Martin Nugent
01254 828060
D3/11/1064

Drafted 2 April 2012

**Outline Planning Application, Ribble Valley District
3/11/1064 Primrose Mill (second phase) and Woone Lane, Clitheroe**

Revision	Description	Date
CLIENT		
BECK DEVELOPMENTS LTD		
PROJECT		
Proposed Development at Land to the rear of No's 59-97 Woone Lane - Clitheroe		
DRAWING		
PLANNING LAYOUT		
SCALE	DATE	
1:500 @ A3	November 2011	
DRAWING NUMBER	REVISION	
3501/P/001	-

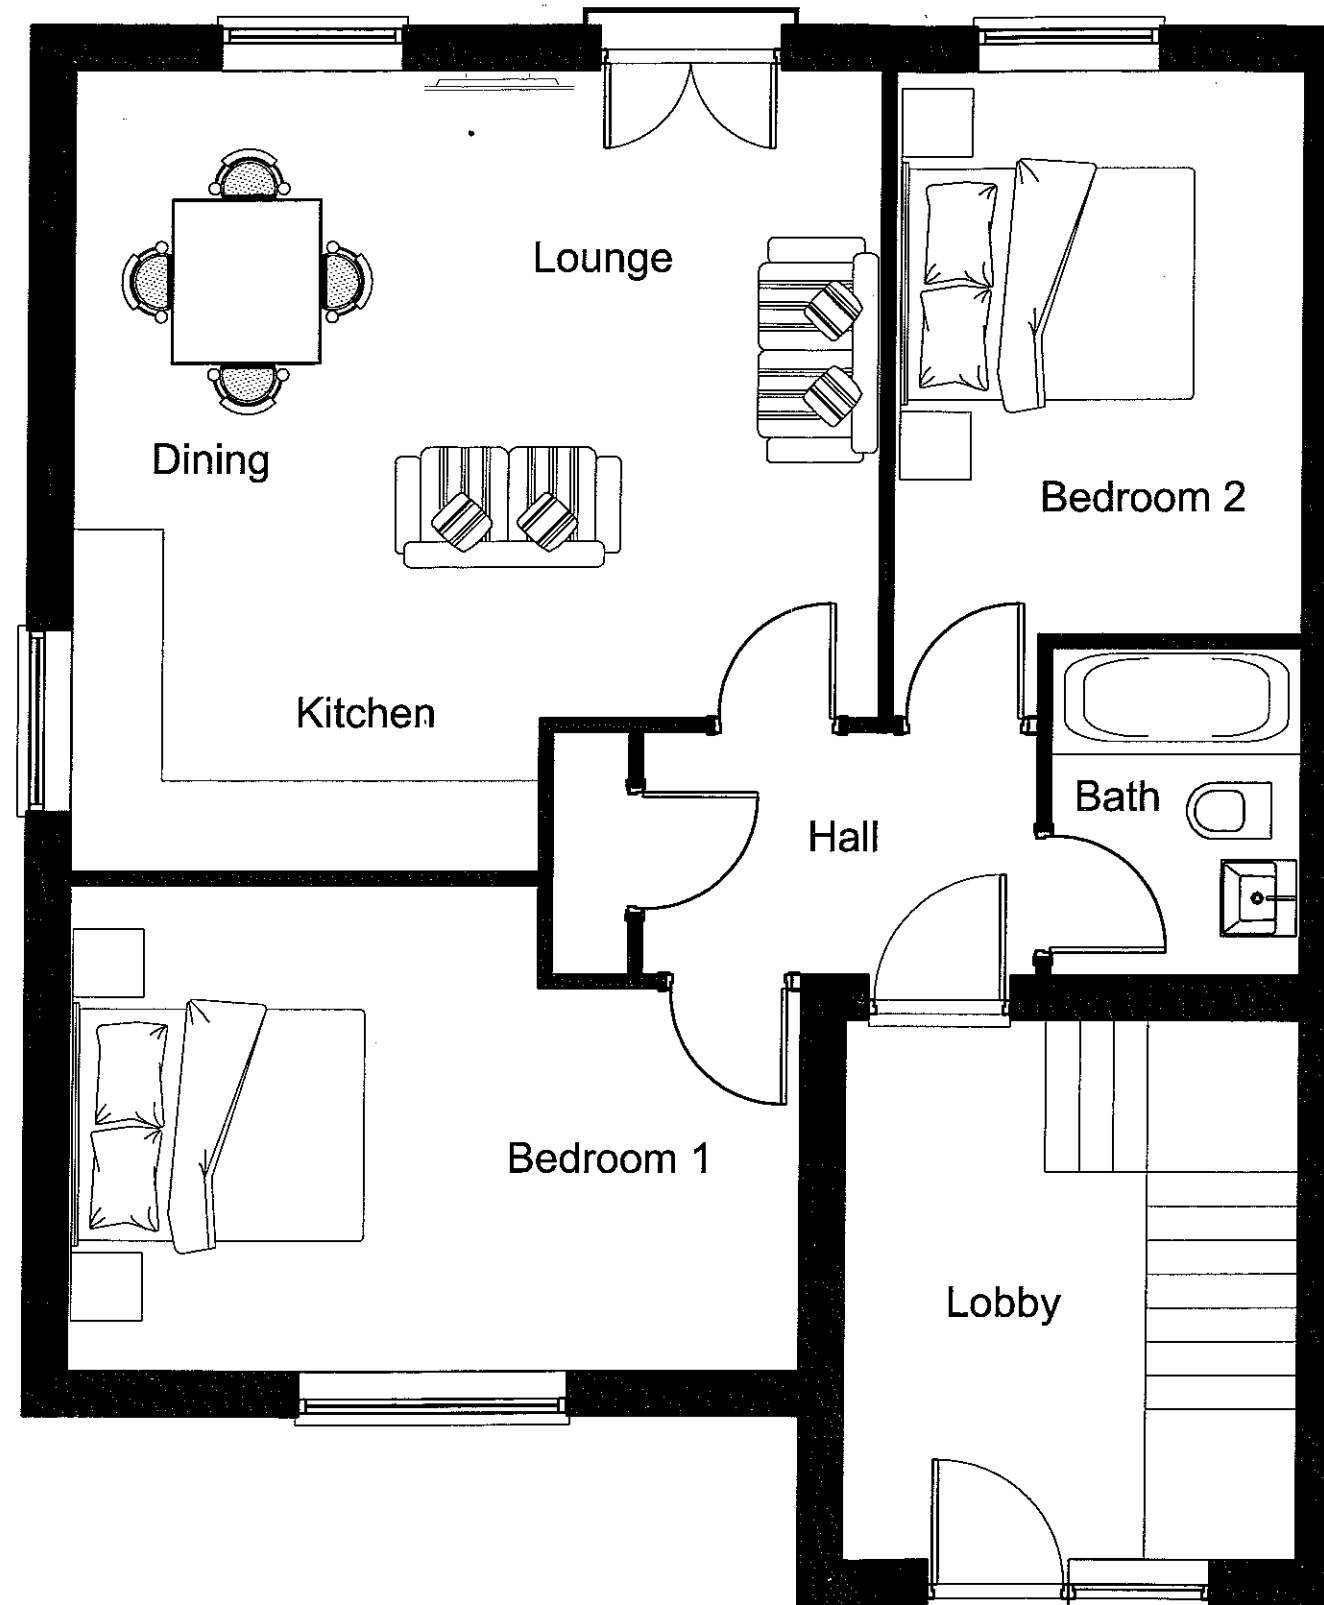
The vehicular access road is 5.5m wide for over 60m from Woone Lane. This is sufficient to accommodate two-way movements and to facilitate safe manoeuvring to/from Woone Lane and the car parking areas to the north east of the junction.

The visibility splay provided secures sightlines in both directions of 2.4m by 43m. This is consistent with MfS2 for roads with a 20mph Speed Limit.

The provision of 2.0m wide footways to either side of the junction for the extent of the frontage onto Woone Lane is also to be welcomed.

The gradient along parts of the access road is up to 1 in 15. While this is in excess of the 1 in 20 we would recommend for an access falling from a priority road, it serves a short residential cul-de-sac, with limited access required for additional traffic.

Should consent be granted for this site, I would ask that every effort be made to minimise the gradient as it approaches Woone Lane, with the aim of securing the recommended 1 in 20 for the first 20m of the access road. However, I recognise that this may be constrained by the access requirements of Plots 8-11 and the parking for Plots 1-7.

However, in order to discourage on street parking on Woone Lane in front of Plots 1-7, there should be no break in the fence or other barrier between the properties and the adjacent footway.
